DRB Project Number: 1006697
Loop Industrial District

SUBJECT: Site Plan for Building Permit

Application Number: 18DRB-70103

Project Name: Silver Star Auto Haus

1 EAST ELEVATION  
SCALE: 1/8" = 1'-0"

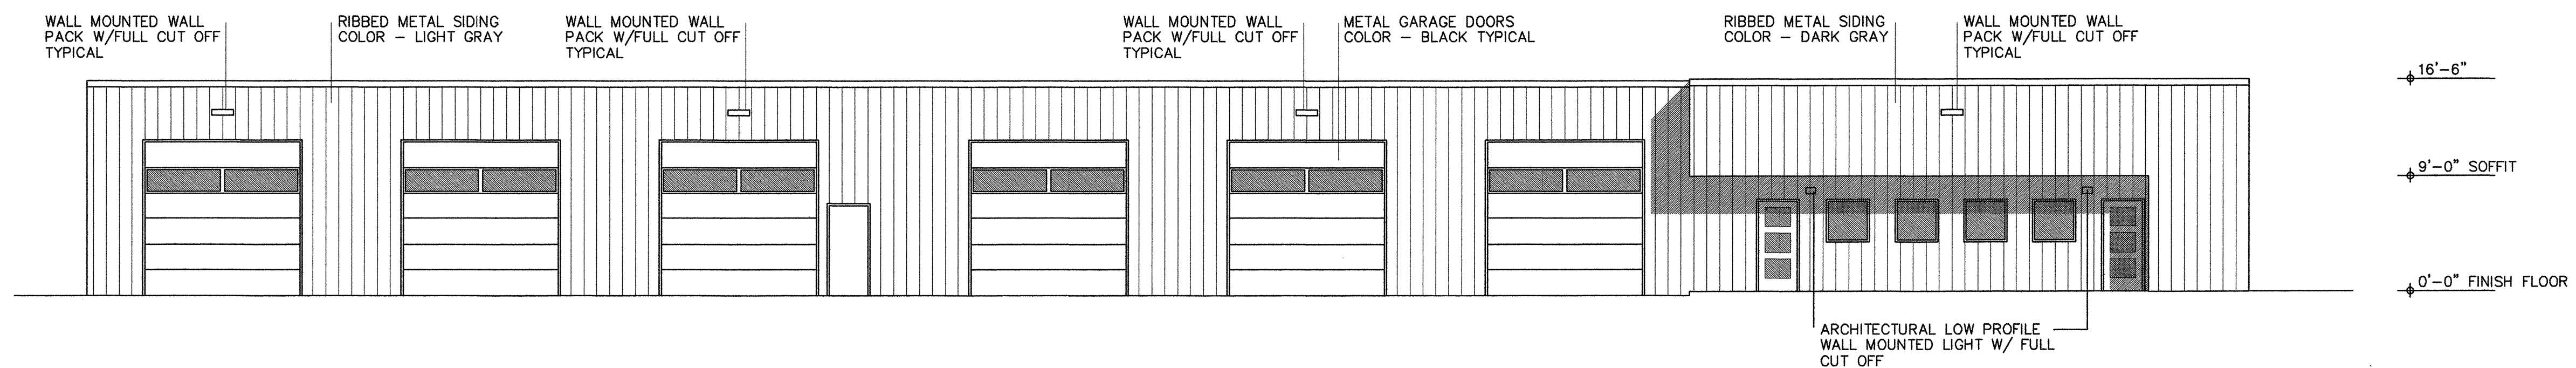
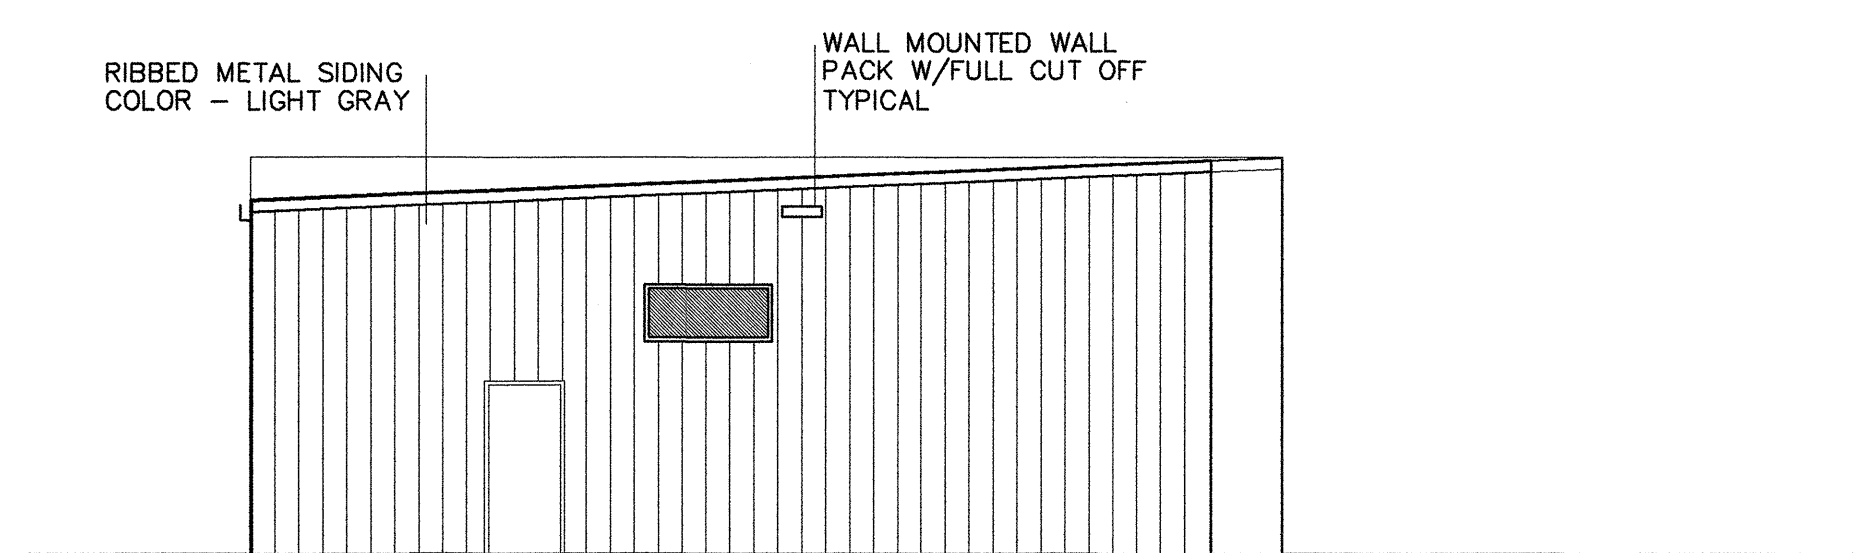
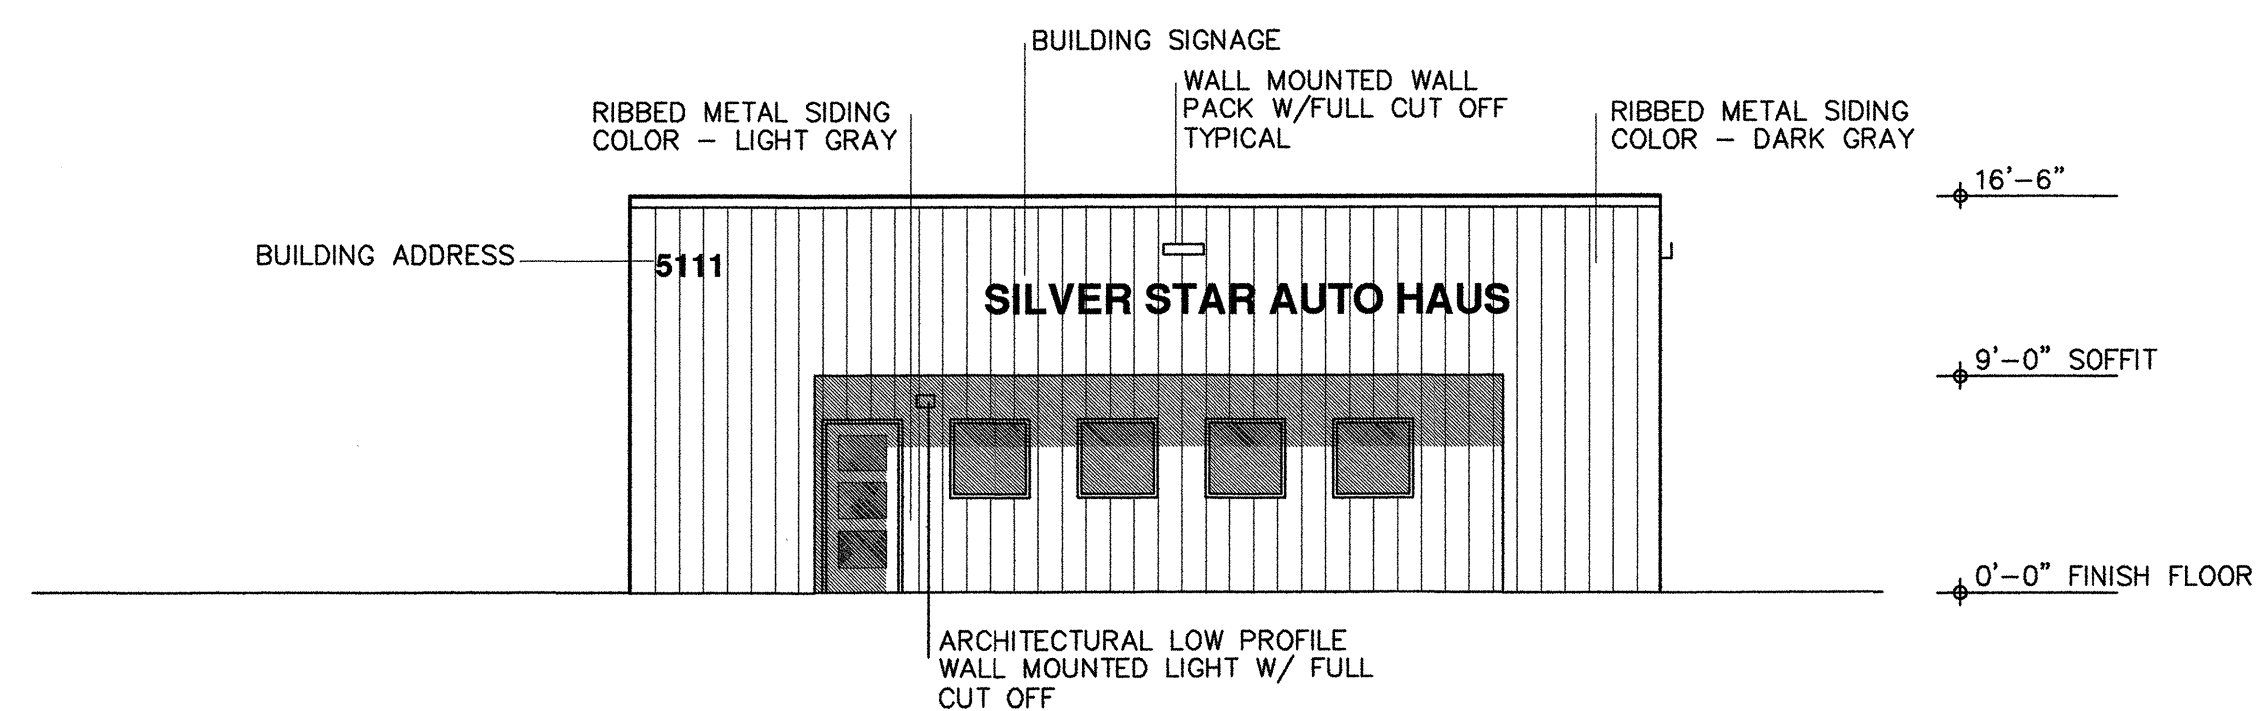
5. Floodlights must not exceed 75 watts and must be mounted between 6 and 14 feet above the grade. Add note to building elevation sheet and make sure to dimension the location of the lights shown currently on the facades.

7. A minimum 6 foot landscaped strip shall be maintained between parking areas and adjacent lots. Must be called out/dimension on LSP.
8. Facades with a length of 100 feet or more shall incorporate wall plane projections or recesses having a depth of at least 3 feet and extending at least 20% of façade. How does the western façade meet this requirement? (B (4) page 36)

9. Location of mechanical equipment? There are screening requirements for roof mounted (C (1) page 36)
10. Building facades require a minimum of 2 different finishes. How has this been addressed on the building facades? (D (1))

11. All primary building facades shall use durable and quality material. How does metal siding meet this? Metal siding is prohibited in some master plans because it is not considered quality.

SIGN DETAIL

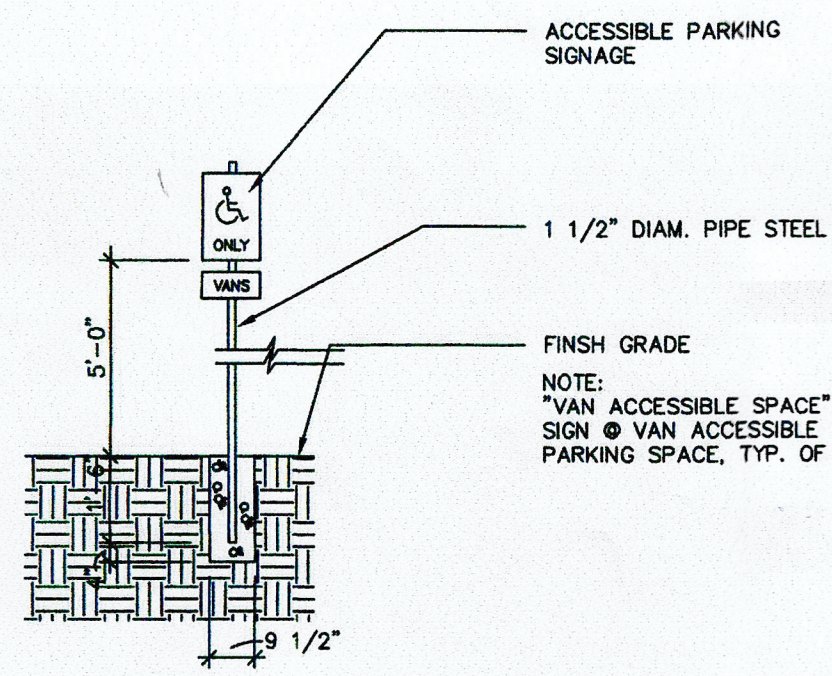
1. The ADA accessible parking sign must have the required language per 66-7-352.4C NMSA 1978 **"Violators Are Subject to a Fine and/or Towing."** Please call out detail and location of HC signs.

SITE PLAN

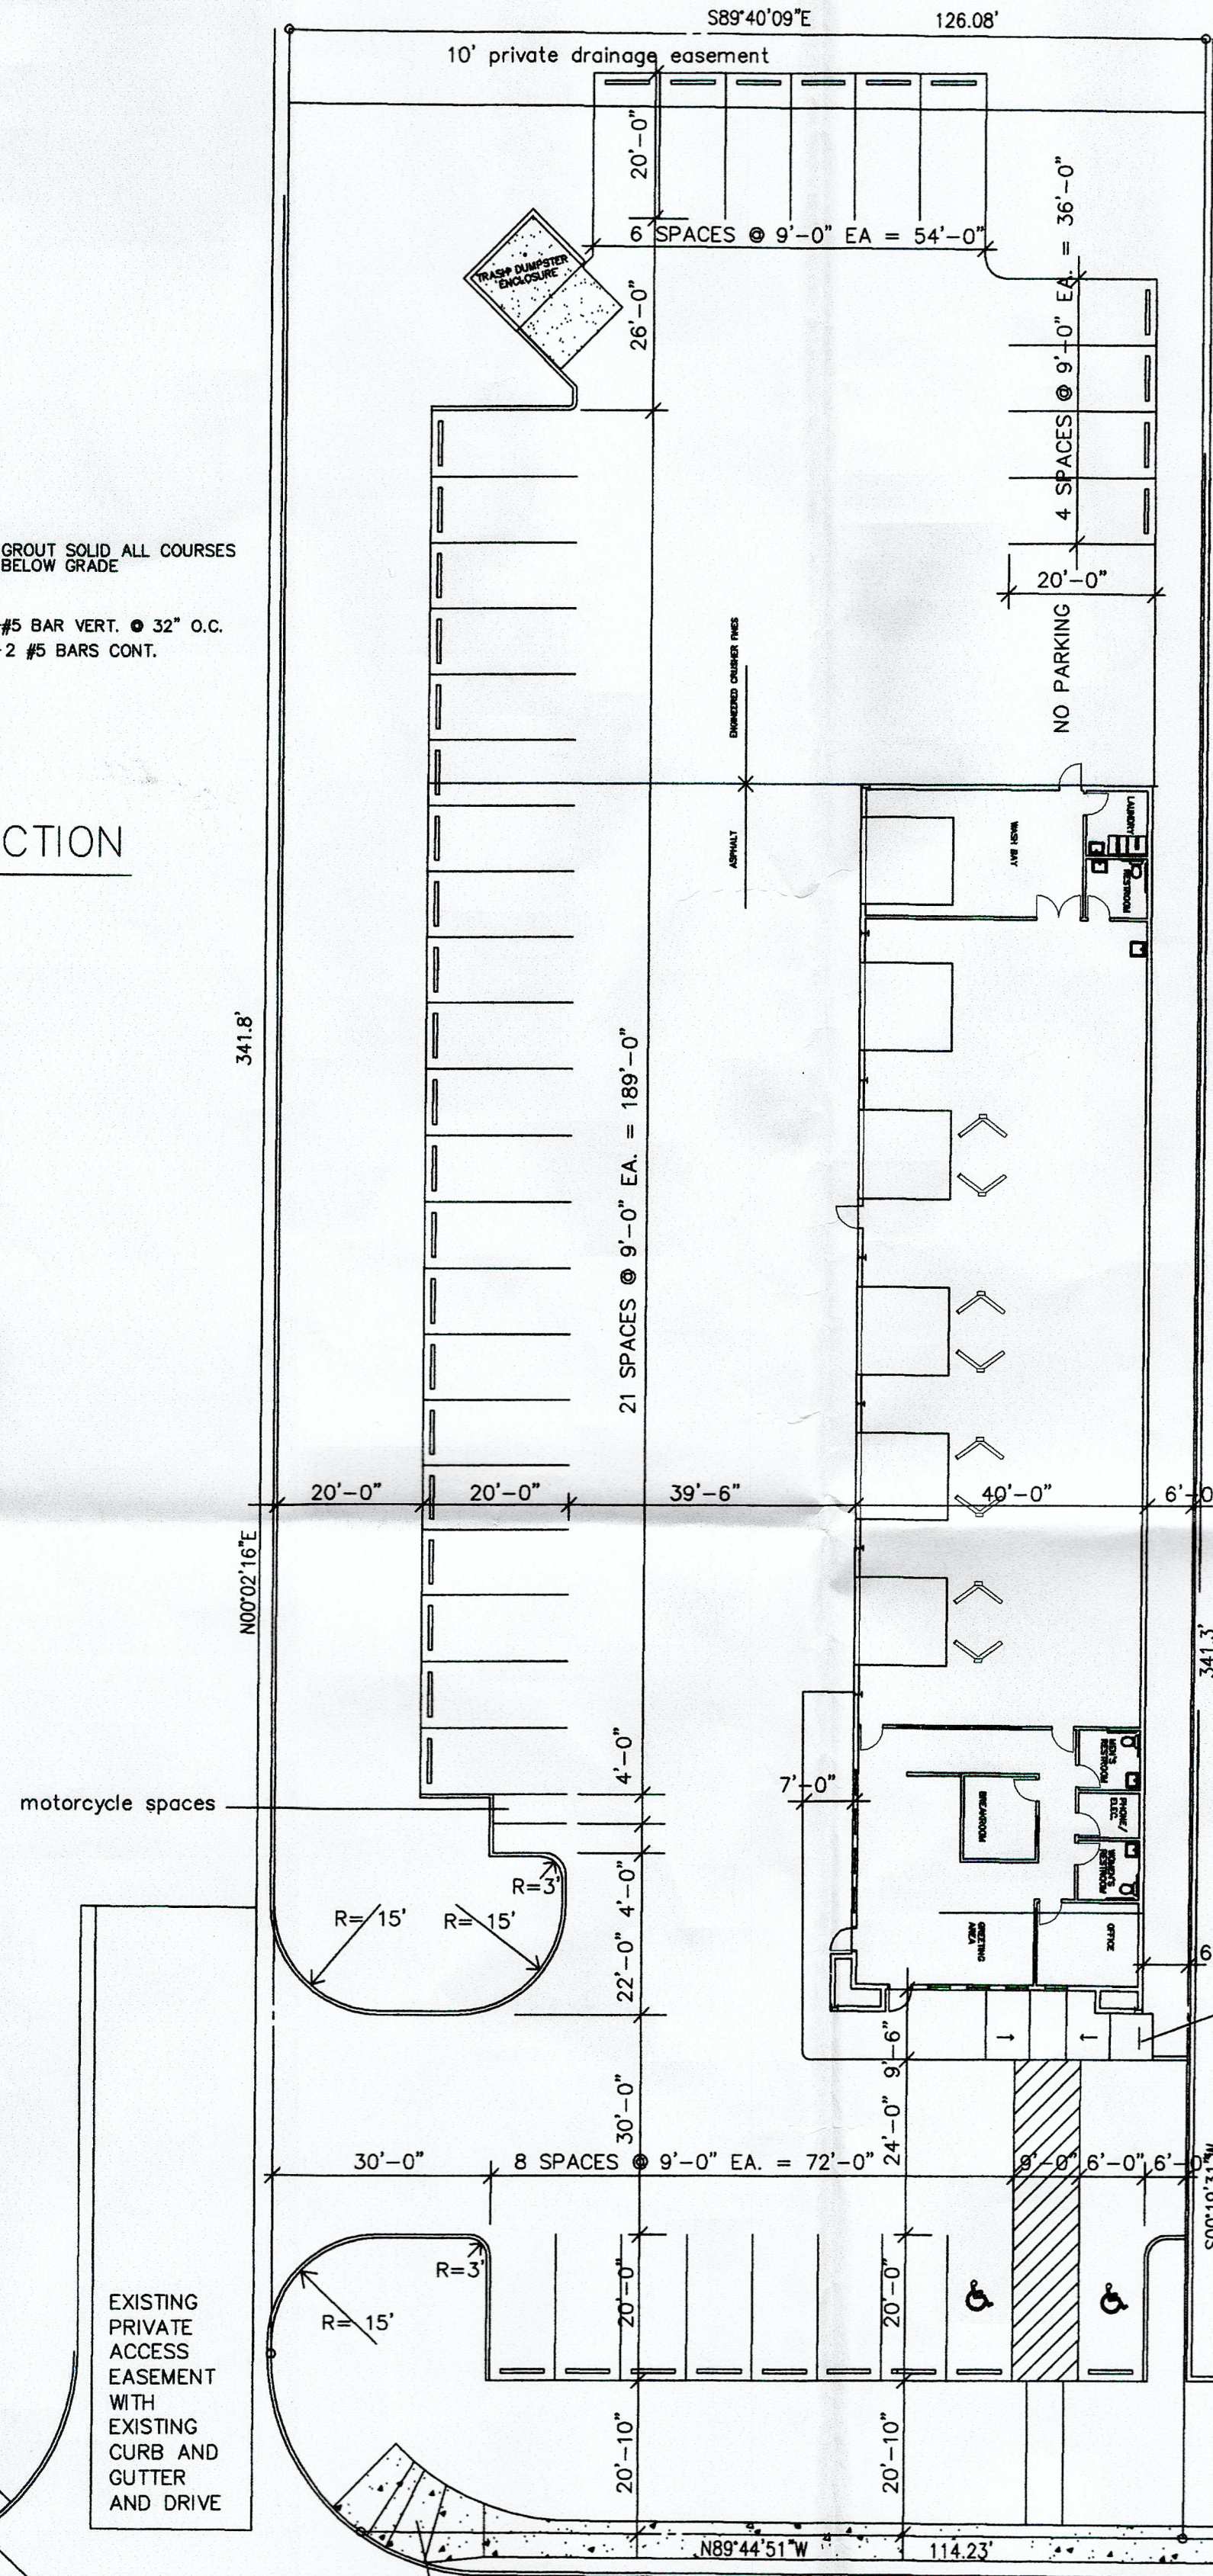
2. The ADA access aisles shall have the words **"NO PARKING"** in capital letters, each of which shall be at least one foot high and at least two inches wide, placed at the rear of the parking space so as to be close to where an adjacent vehicle's rear tire would be placed. (66-1-4.1.B NMSA 1978)

3. Motorcycle parking spaces shall be designated by its own conspicuously posted upright sign, either free-standing or wall mounted per the zoning code.

4. Per the zoning code, a 6 ft. wide ADA accessible pedestrian pathway is required from the public sidewalk to the building entrances. Please clearly show this pathway and provide details.

5. Per DPM, a 6 ft. wide ADA accessible pedestrian pathway is required from the HC parking stall access aisles to the building entrances. Please clearly show this pathway and provide details.

6. Provide a min 6" or max 8" high concrete barrier curb or other acceptable barrier between landscaping and parking areas and/or drive aisles. Please call out detail and location of barrier curb.

2. Distinguish pedestrian surfaces or key pedestrian way from driving surfaces through the use of special materials such as special pavers, bricks or scored concrete to enhance pedestrian safety (page 32). Label the material on the site plan. Currently it just looks like painted striping.

3. Looks like there is a pedestrian connection from the parking lot to the public sidewalk but it is not labelled or dimensioned.
4. Sidewalk is to be provided along the full length of the building along any façade featuring an entrance. It appears this has been met but there is no labelling.
